Application Correspondence

From: Simon Davis
Sent: 24 November 2017 11:40
To: 'Andrew Knowles'
Subject: 14 Princess Avenue, Bognor Regis - AW/328//17/OUT

Drg No.: SBS/221/06C

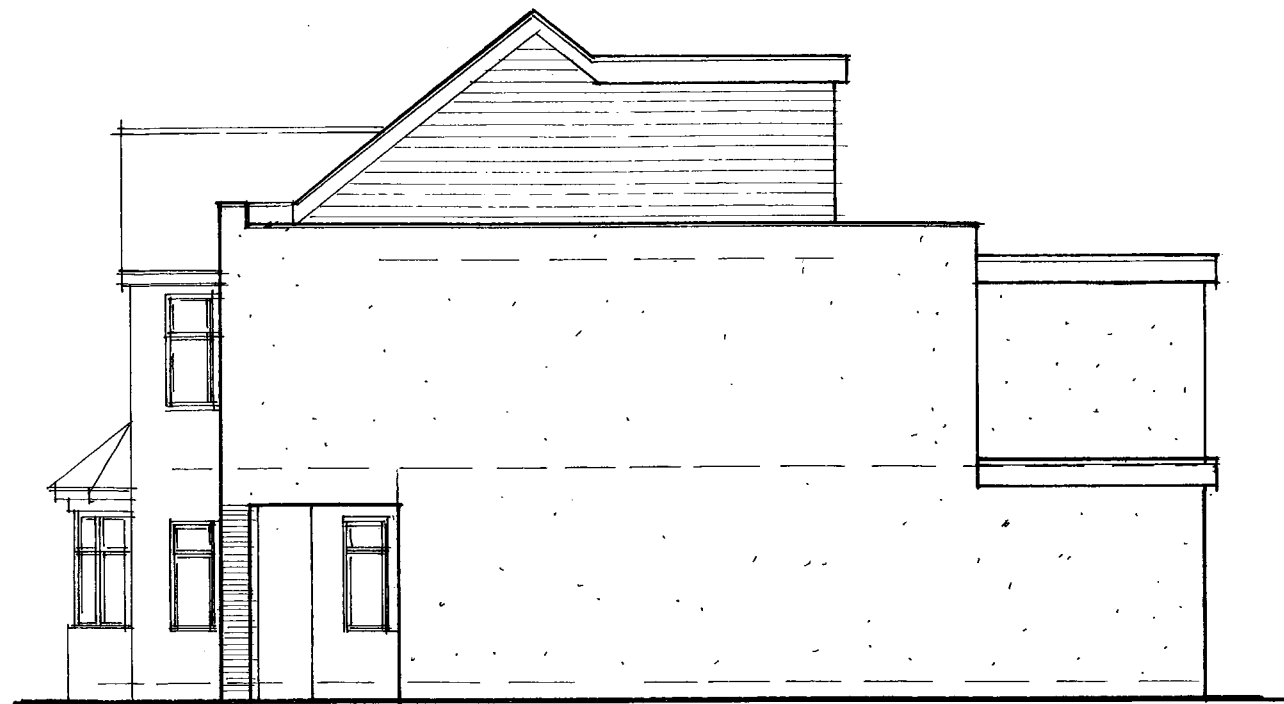
I previously asked that the proposed north facing roof level bedroom window be either obscure glazed or with a sill level of 1.7m. Could you amend the elevations drawing to show this?
